From: Ross Leal
Sent: 10 March 2015 12:55
To: [REDACTED]
Subject: RE: BR/259/14/PL - Unit 1, 5 Waterloo Square, Bognor Regis
Attachments: 201503101254.pdf

From: Ross Leal
Sent: 09 March 2015 16:35
To: 'crossroadscars@live.co.uk'
Subject: BR/259/14/PL - Unit 1, 5 Waterloo Square, Bognor Regis

OS MasterMap 1250/2500/10000 scale
 21 October 2014, ID: HMC-00370730
www.themapcentre.com

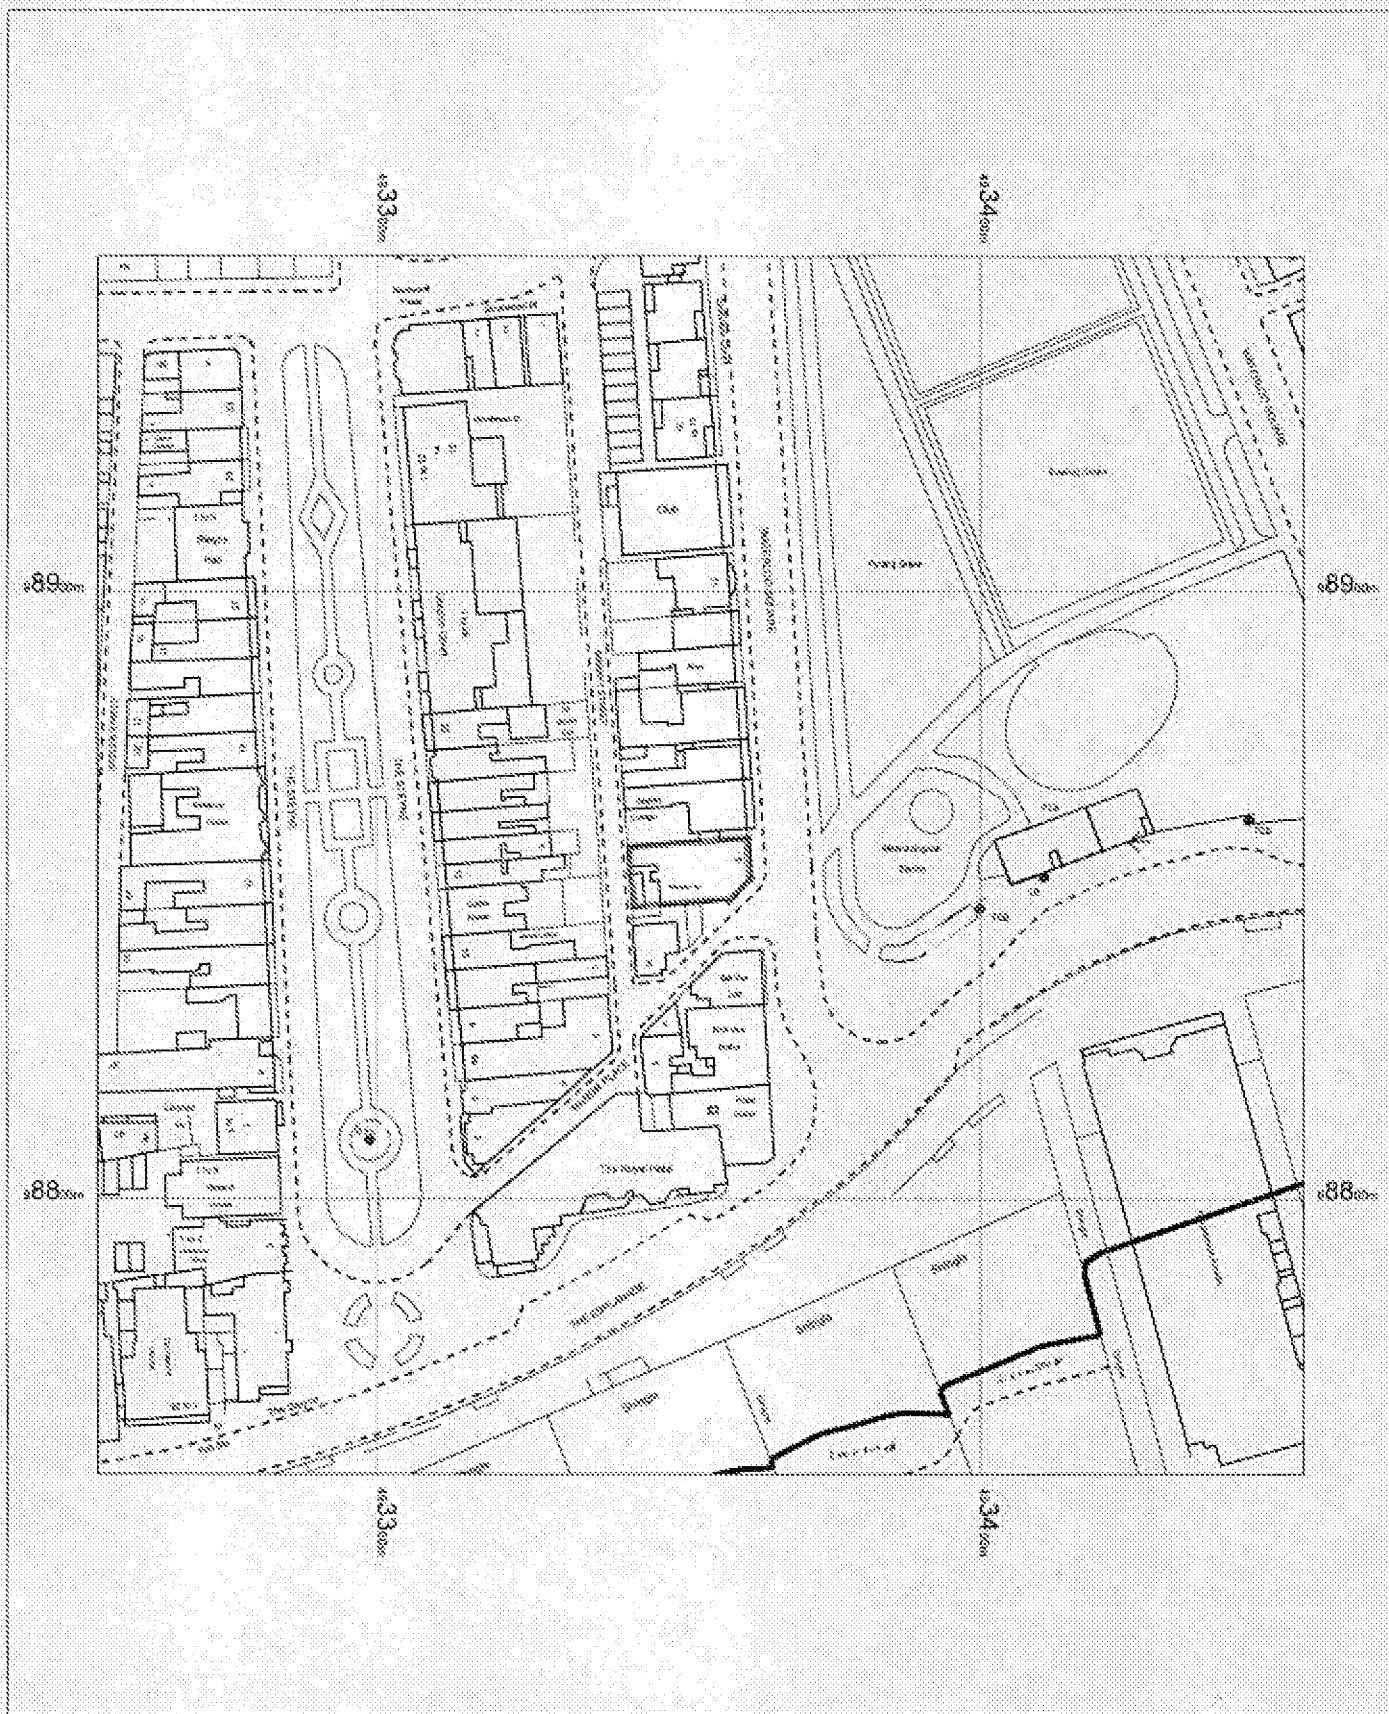
As discussed, please revise your location plan so that the walled of area is included within the red edge and the open area edged in blue. (See photo attached).
